Application for a non-material amendment following a grant of planning permission.
Town and Country Planning Act 1990

House name: **NORTH LODGE BARN**

Reference: **DC/23/02597**

CHANGE VERTICAL SECTIONS TO FRONT ENTRANCE TO SOLID BAR INSTEAD OF COUPLED FRAMES

FRONT ENTRANCE  
PROPOSED REVISION

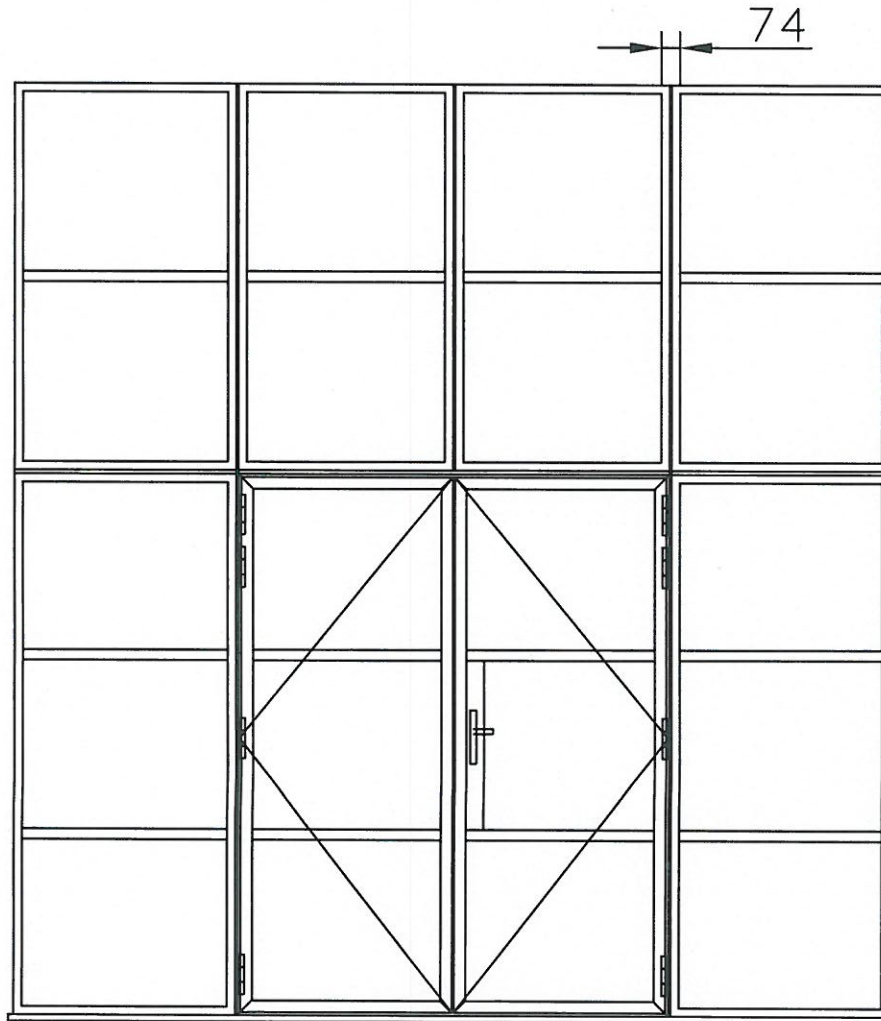
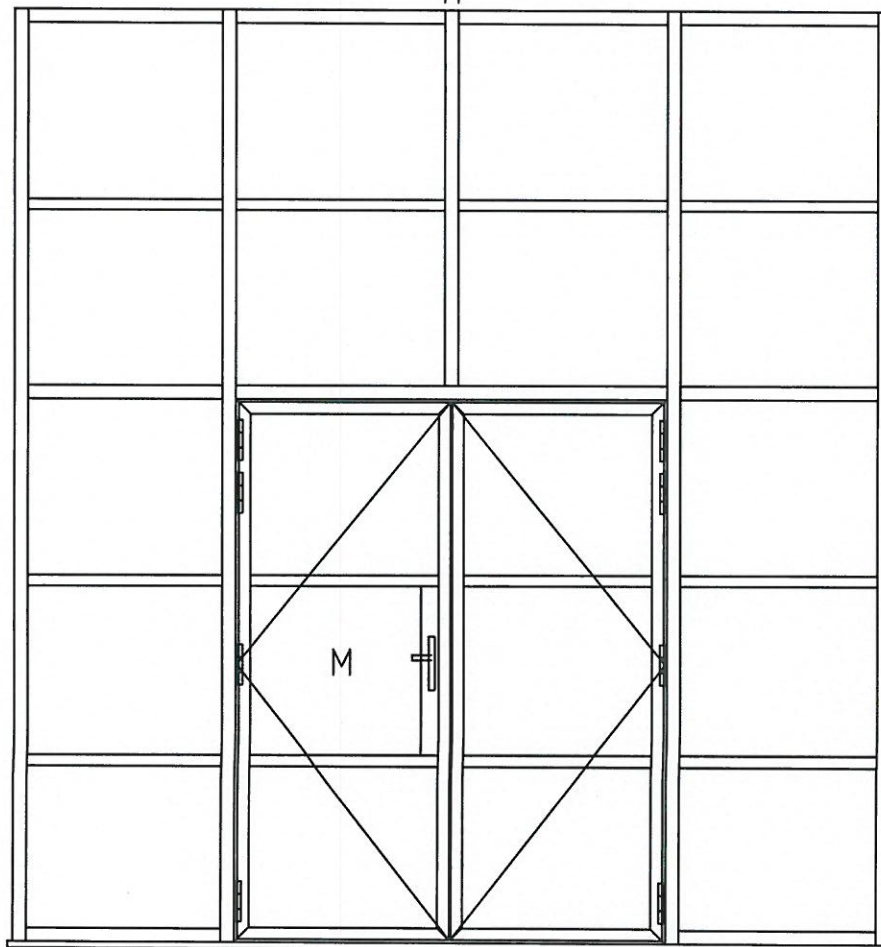
TO CHANGE THE TYPE OF BARS USED FOR FRONT ENTRANCE FROM 3 BAR COUPLED TOGETHER TO ONE SOLID BAR RM STRENGTH ALSO CHANGE HORIZONTAL BARS IN WINDOWS FROM 4mm TO 25mm WHICH IS MORE IN KEEPING WITH TRADITIONAL WINDOW DESIGN

FRONT ENTRANCE CHANGE RM STRENGTH DUE TO WIND RESISTANCE WINDOWS TO MAKE APPEARANCE BETTER AND MORE LIKE TRADITIONAL BARS

1B 2A 2B
